# Byers Gill Solar EN010139

## 3.3 DCO Schedule of Changes

Deadline 8 – January 2025

Revision 7

Drawing Title
Street Works, Public Rights of Way & Access Plans
 Sheet 11 of 13
APFP Regulation 5(2)(k)

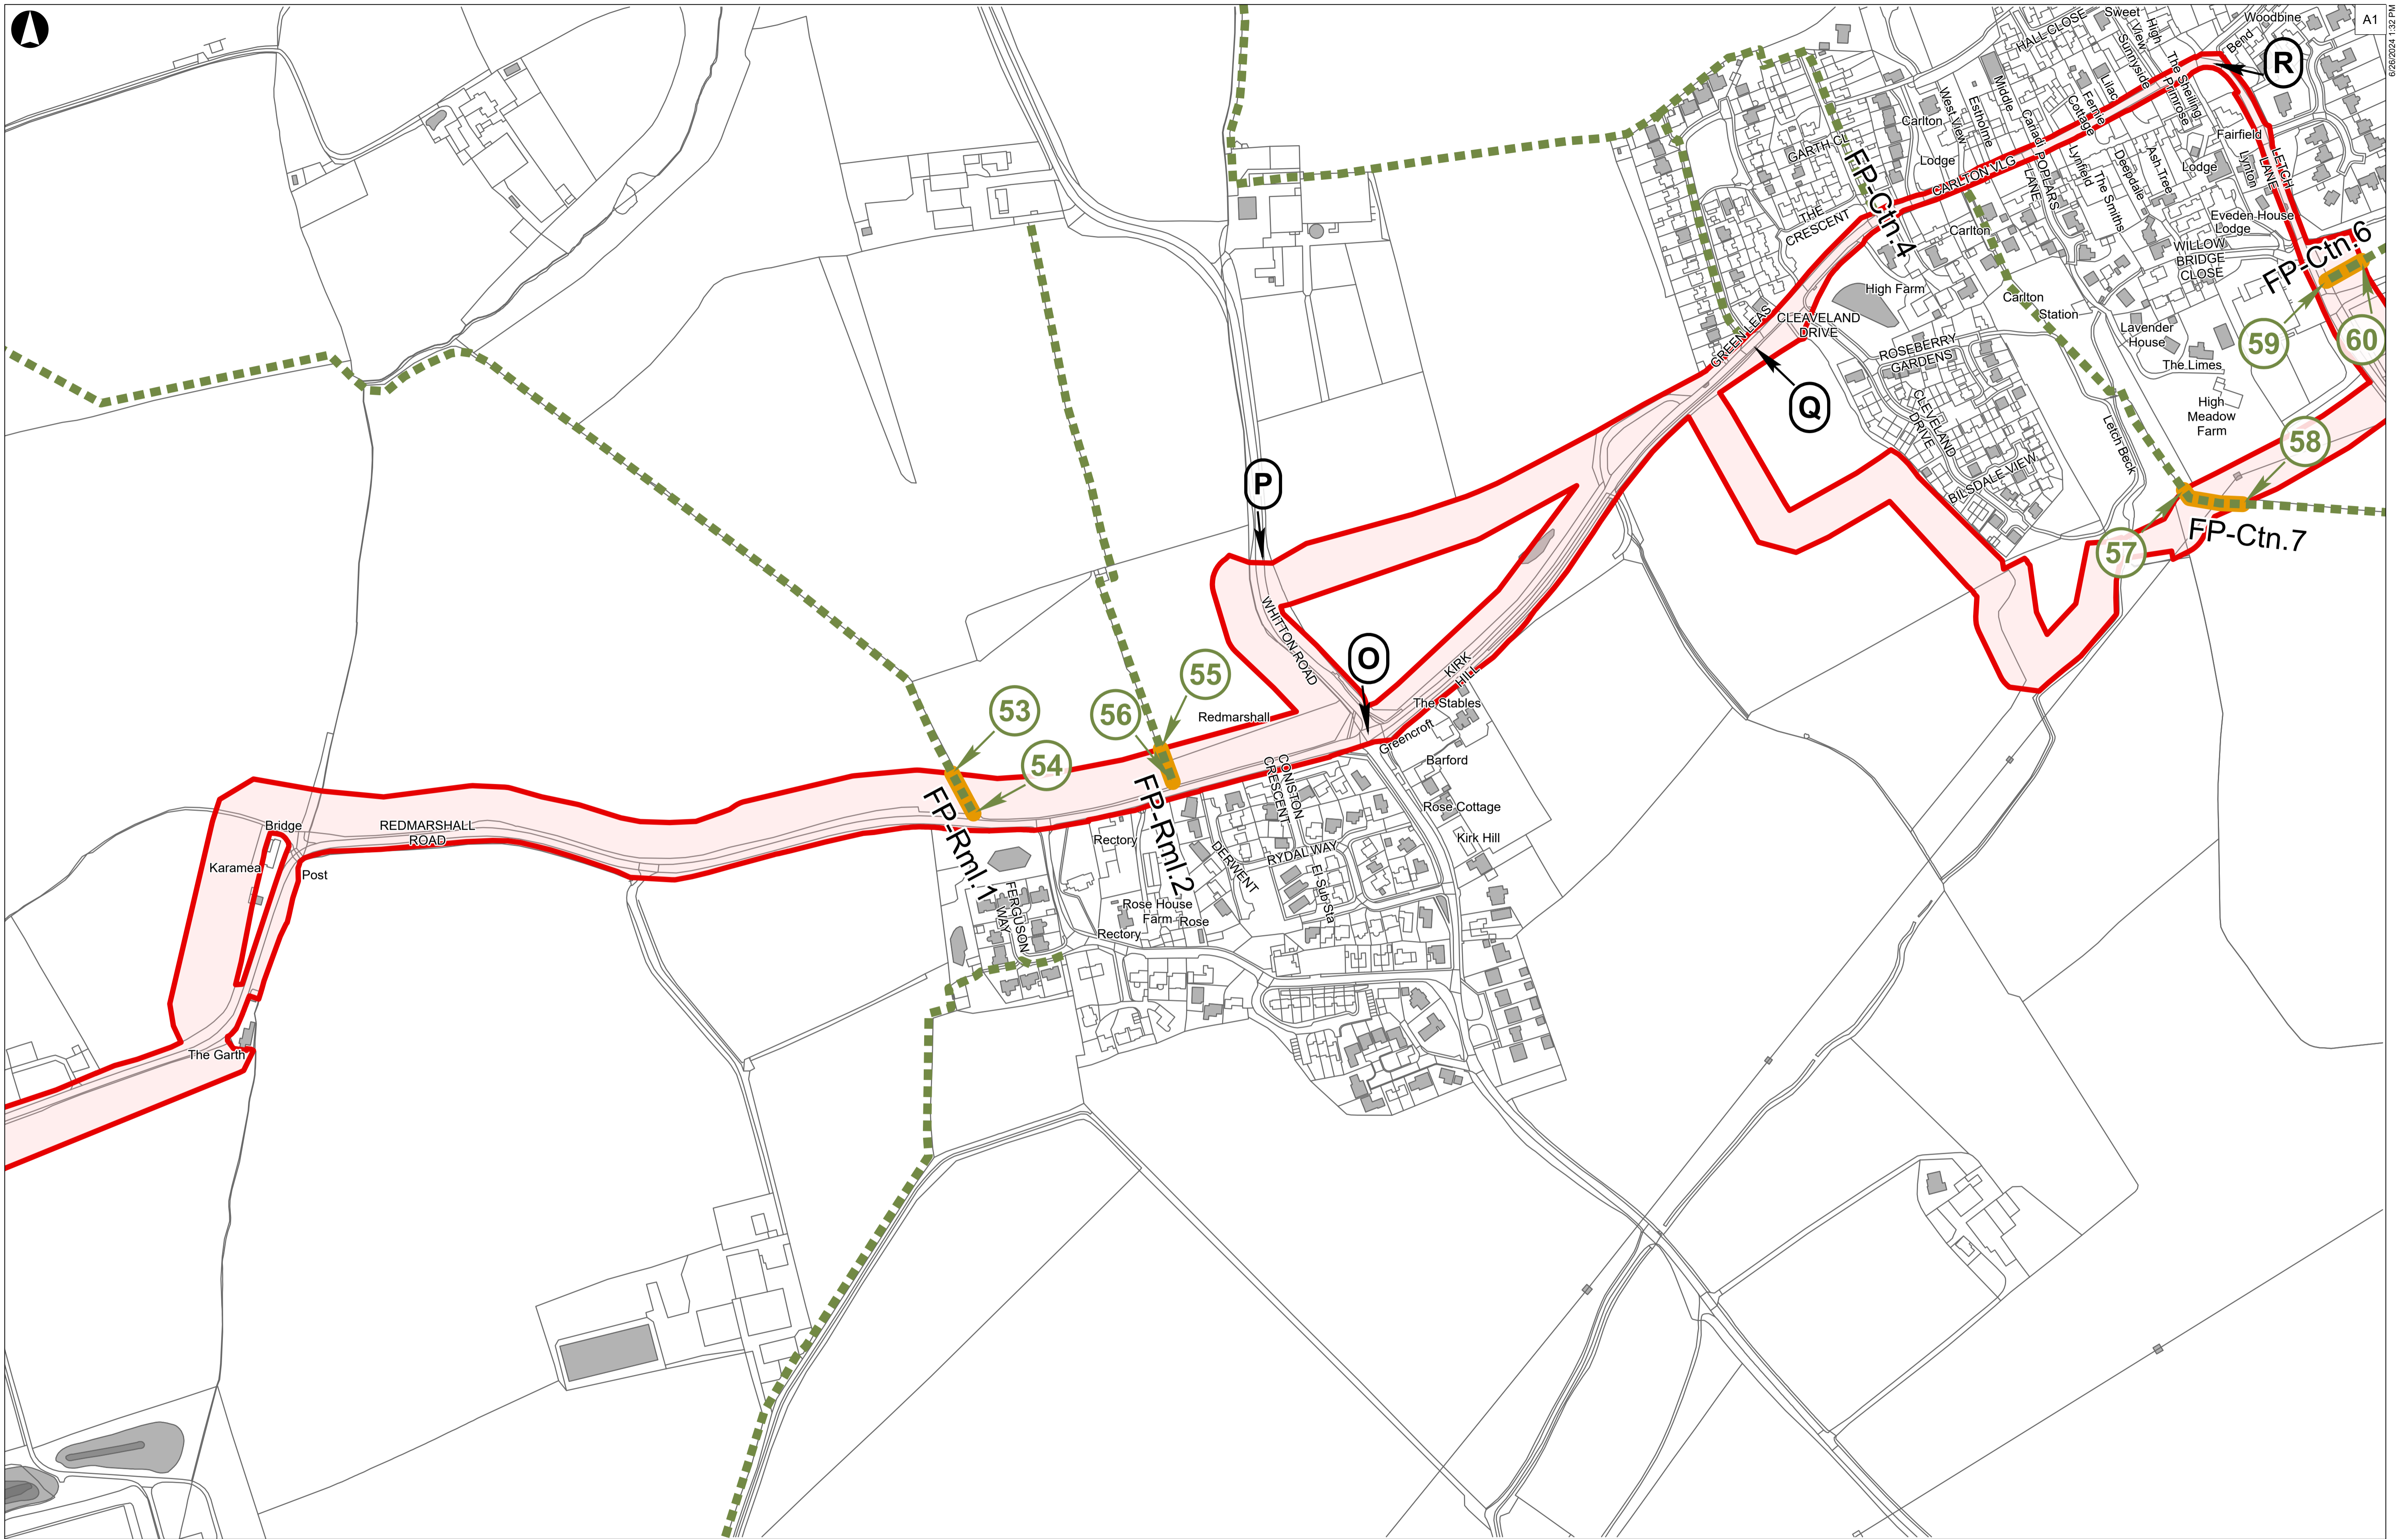
<u>Parish of Bishopton</u>	<u>Folly Bank</u>	<u>Cable works beneath the width of street as shown with reference CC5 on sheet 9 of the street works, public rights of way and access plans.</u>
<u>Parish of Redmarshall</u>	<u>Redmarshall Road, in the vicinity of Morrington Bridge</u>	<u>Cable works beneath the width of street as shown with reference CC6 on sheet 11 of the street works, public rights of way and access plans.</u>

These two rows have been added to provide street works descriptions for two locations where the Applicant proposes to carry out cabling works across the width of a street for the purpose of delivering the off-road cable route. These descriptions are included as a correction to Revision 1 of the dDCO.

Corresponding amendments have been made to the Street Works, Public Rights of Way and Access Plans to indicate these locations.
